GG119 ROAD SAFETY AUDIT RESPONSE REPORT

Project Title:	Castle Hill, Huddersfield
Project Team:	
RSA Report Stage	1_2
RSA Organisation:	Sanderson Associates Consulting Engineers
RSA Report Reference:	156199-002-02
RSA Report Issue Date:	24/11/25
Report Title:	Combined Stage 1-2 Road Safety Audit
Reference:	156199-002-02

This Road Safety Audit Response Report relates to a Stage 1-2 Road Safety Audit carried out on a Passing places Scheme at Castle Hill, Huddersfield. The scheme Castle Hill Visitor Centre

Appendix 2 – Sanderson Associates Drawing No 156199-100-002

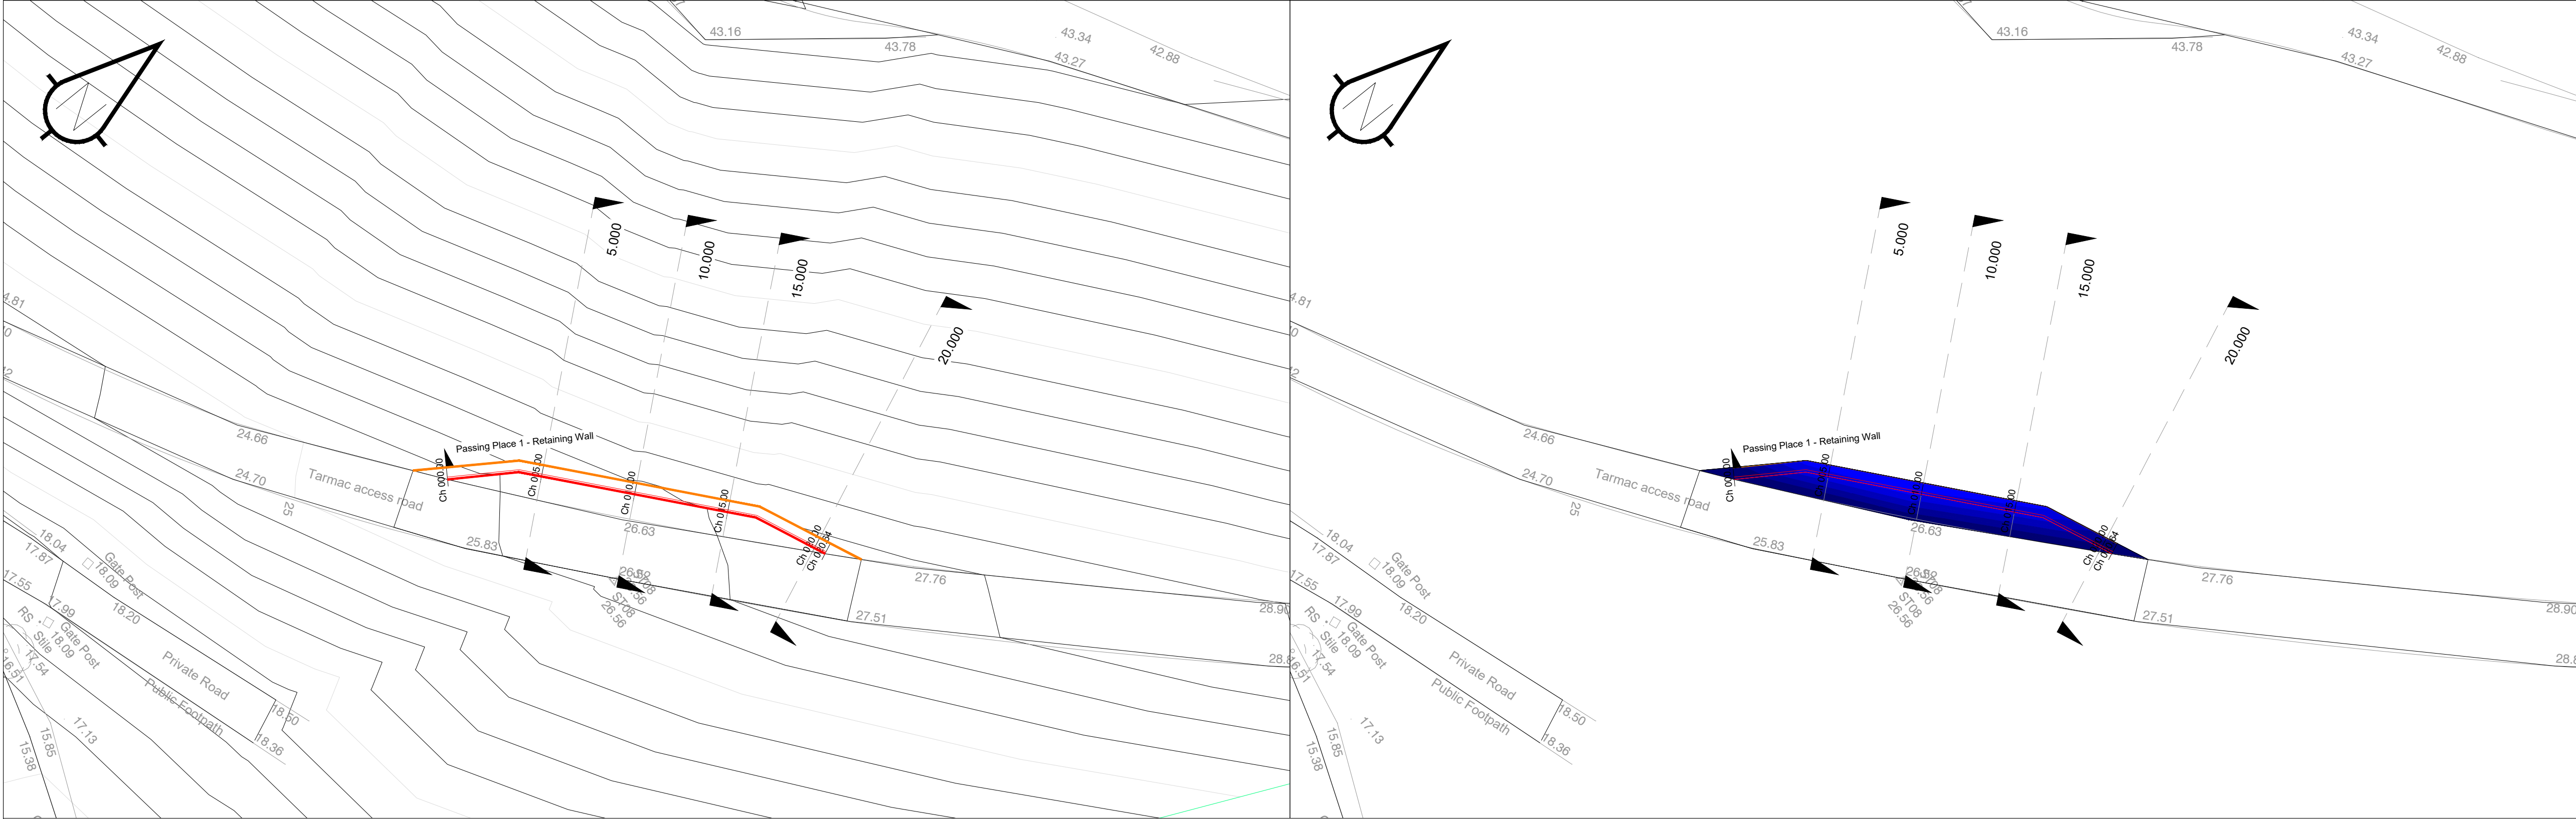
Detail: The drawing 156199-100-001 shows the area of existing foliage to be cleared and notes a strip 3m wide from the edge of carriageway. This is needed to assist in providing forward visibility between approaching vehicles and for drivers to use the passing places accordingly. The concern is that without appropriate visibility it could lead to drivers not making use of the passing places resulting in vehicles reversing as another vehicle approaches from behind with consequent rear shunt type incidents or head on offside vehicular collisions whilst vehicles try to pass each other. The drawing provides no details of the maintenance regime or the height to which the foliage should be cut and trimmed.

Recommendation Provide details of the proposed maintenance regime and heights to which foliage should be cut and trimmed.

The designers acknowledge the recommendation of the Audit team and propose to inform the landowner of the obligations.

Foliage to be trimmed back and maintained accordingly.
